**WELWYN HATFIELD COUNCIL – DEVELOPMENT CONTROL**  
**DELEGATED REPORT**

<b>APPLICATION No:</b>	<b>S6/2008/170/AD</b>
------------------------	-----------------------

The proposal is for the installation of two internally illuminated signs (750H x 2845W x 95D) across the top of the unit at Mail Boxes etc and Hunters estate agent, unit 9, Parkhouse Court, Hatfield District Centre. The Mail Box sign will be white letters on a black background and the Hunters sign will be white and blue letters on a blue and yellow background. The level of illumination for each sign will be 250 cd/m<sup>2</sup>.

Shopfront Elevation - Proposed

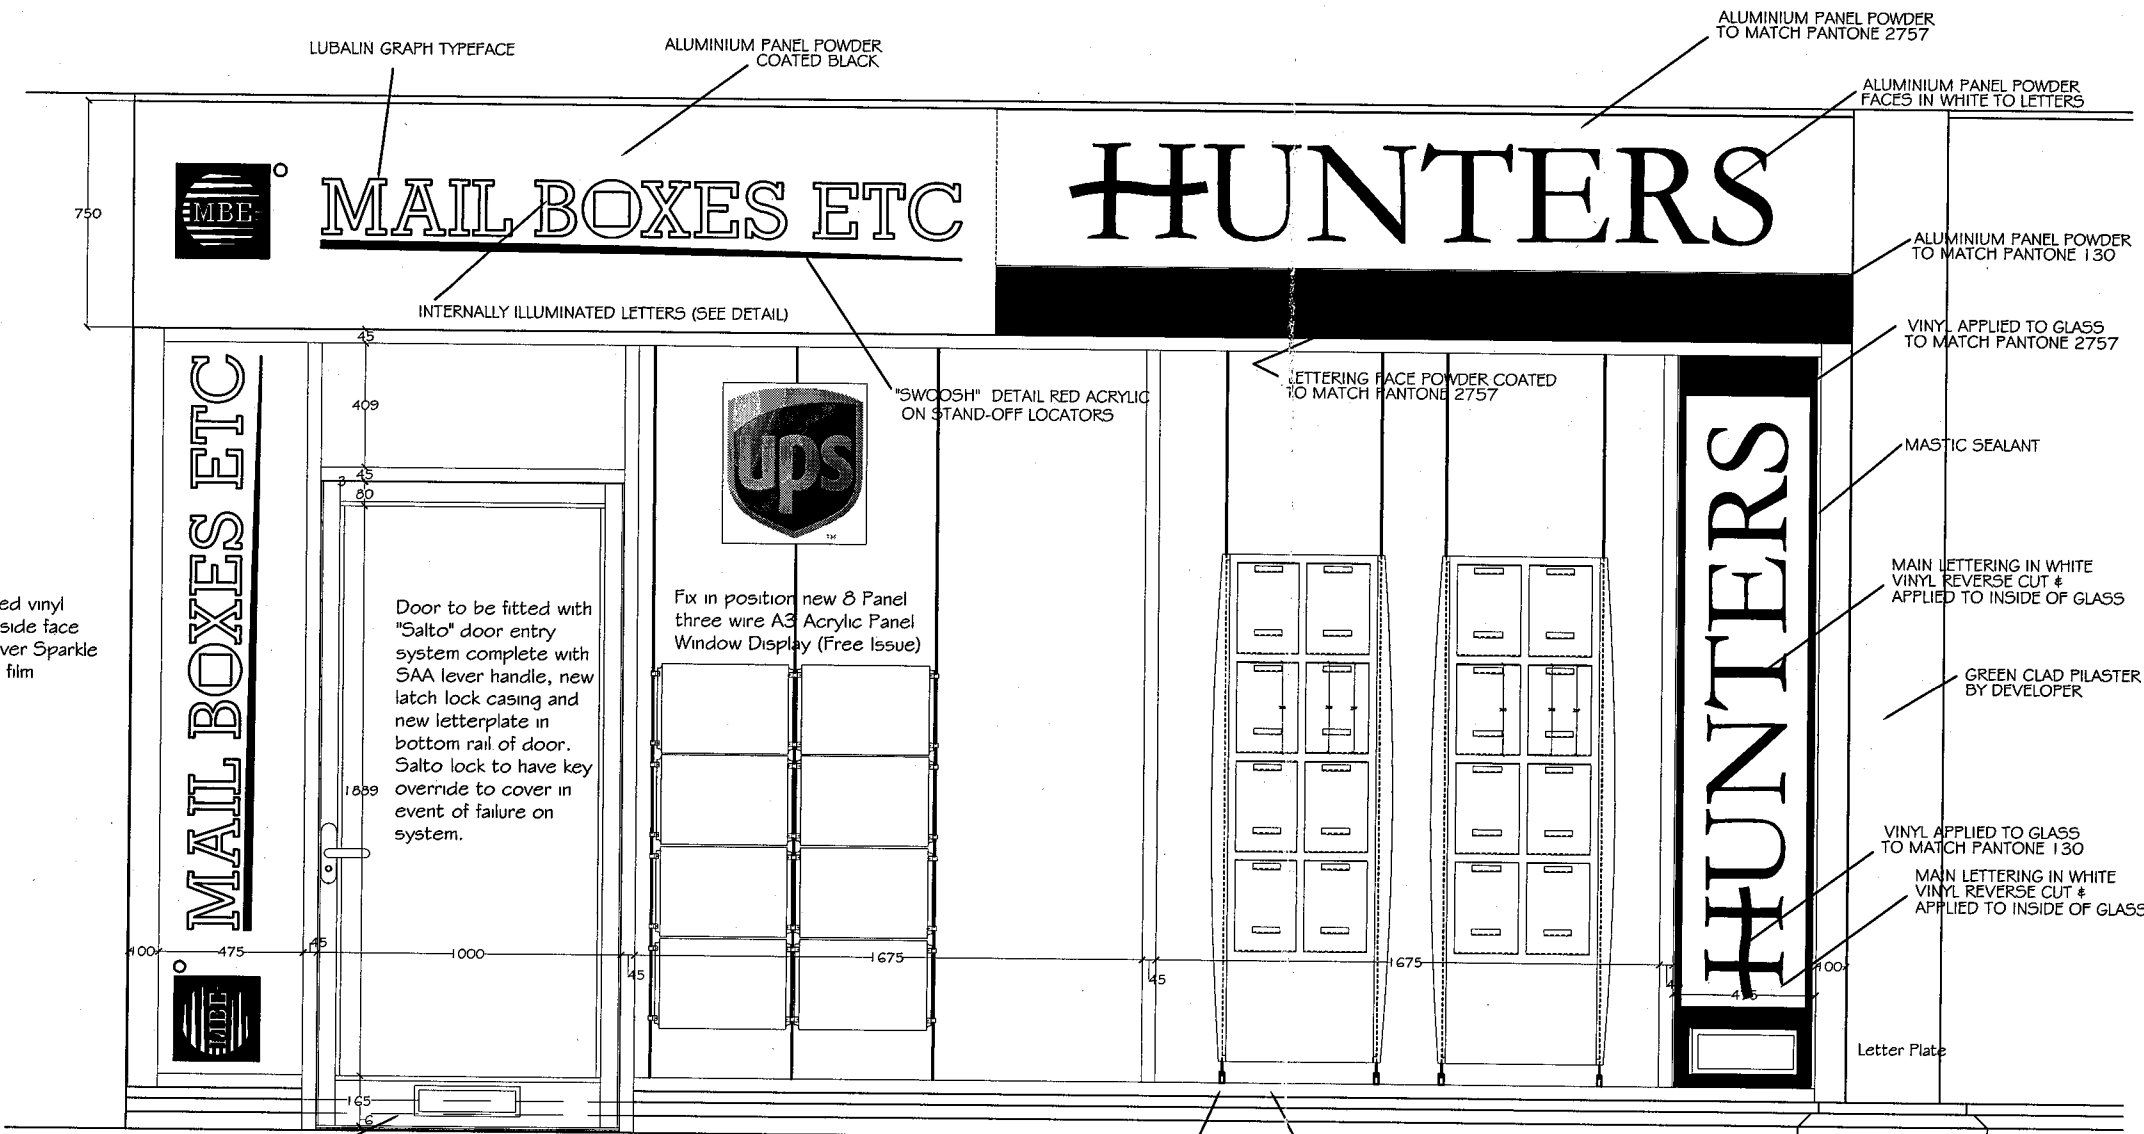
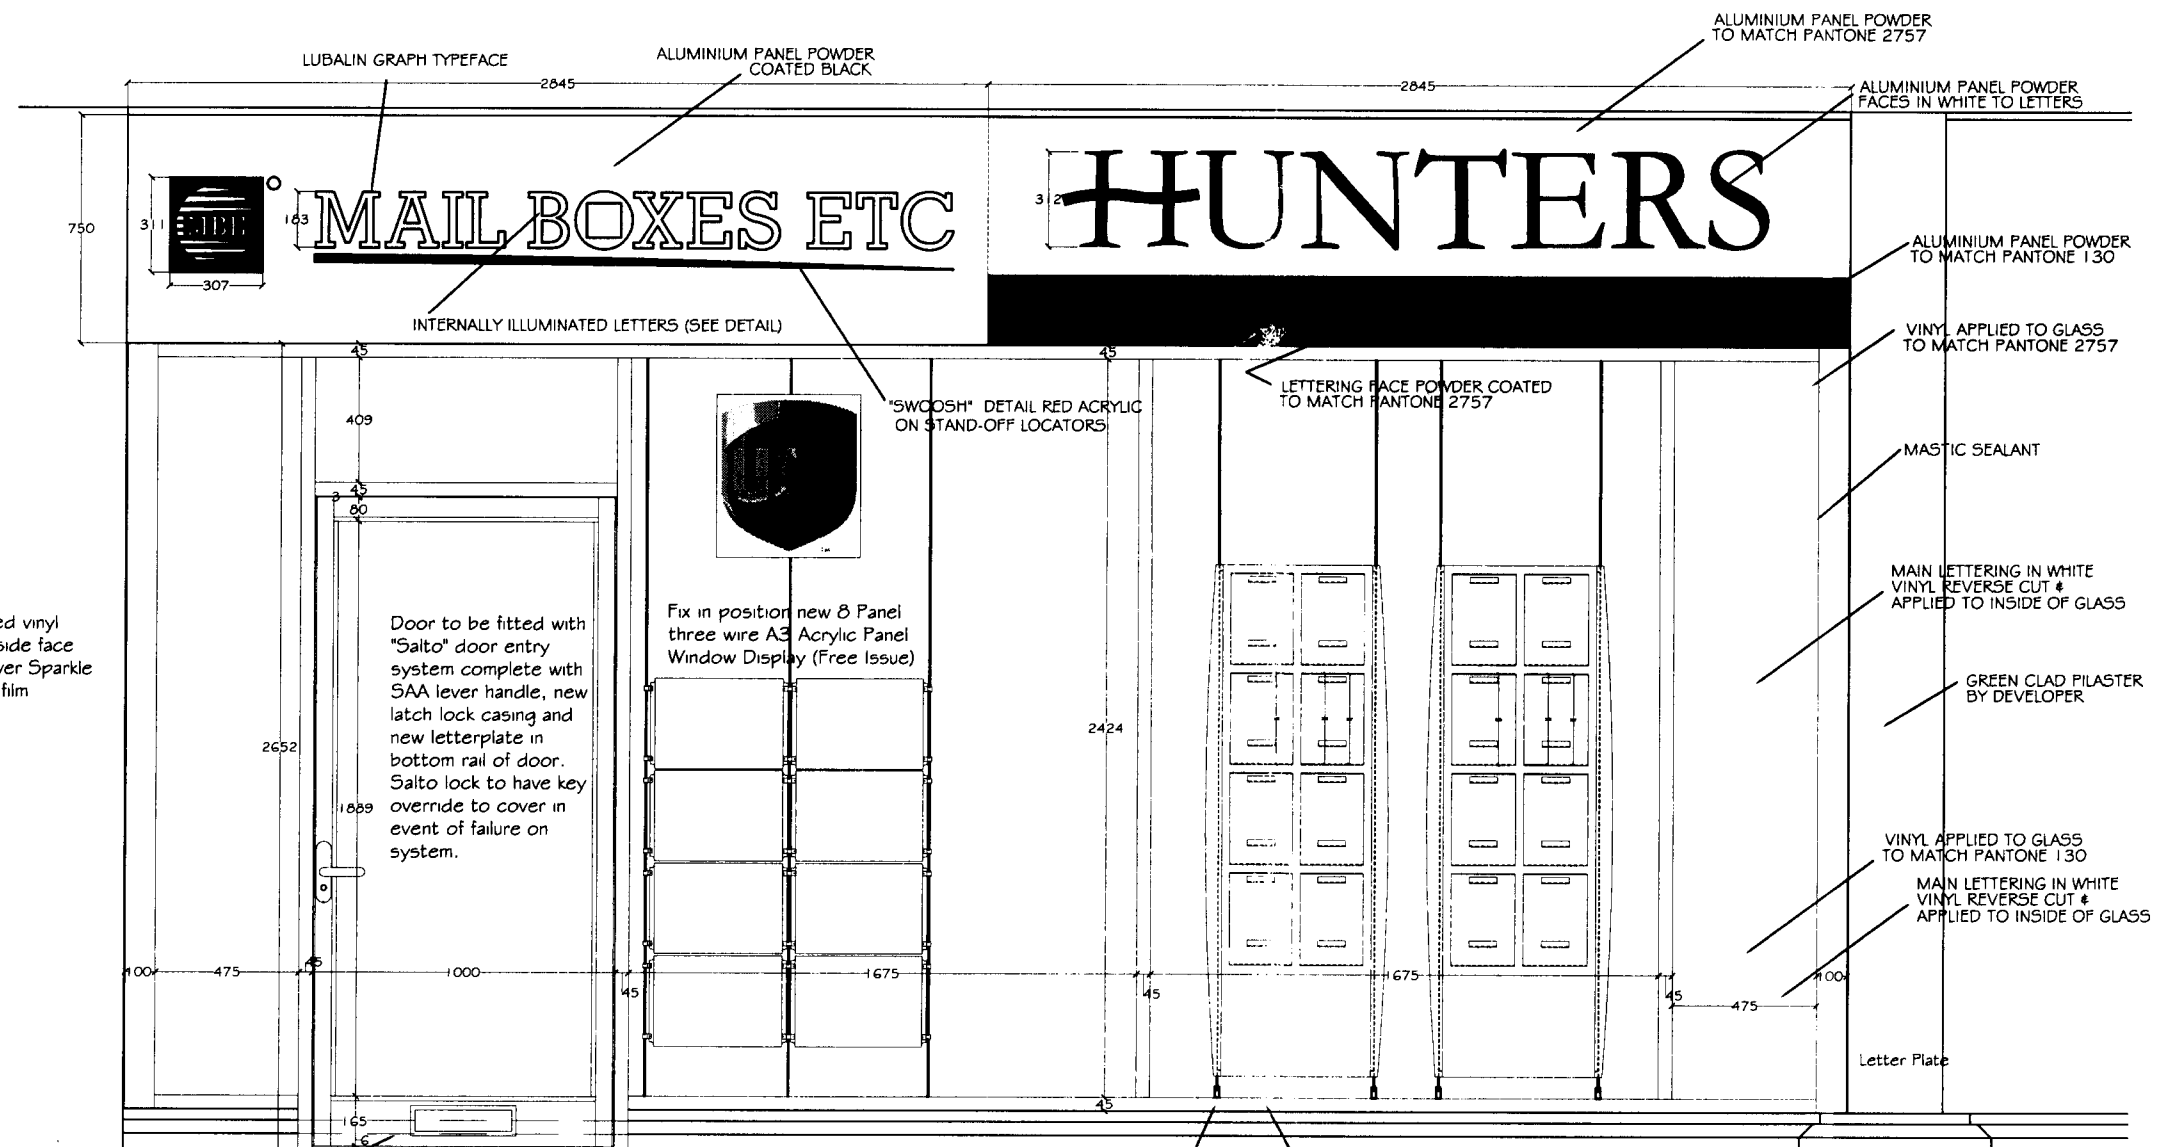
The original application was for the installation of two internally illuminated fascia signs and vertical window lettering that would have been situated at each side of the shopfront. This application was however amended (at our request) to remove the vertical window lettering as it was deemed that this did not reflect the character of the District Centre and would create visual clutter given the amount of signage on a relatively small shopfront.

The proposed signage would not appear particularly prominent within the street scene and would not have an adverse impact upon the character and appearance of the area. The size and position of the proposed advertisements also respects the architectural features of the building and should not create visual clutter. In addition to this, whilst the signs are

illuminated the level of illumination is not visually intrusive and will not impact on public amenity.

Amended Plan - Shopfront Elevation As Proposed (drawing number WD/1050/05 A) date stamped the 11<sup>th</sup> February 2008.
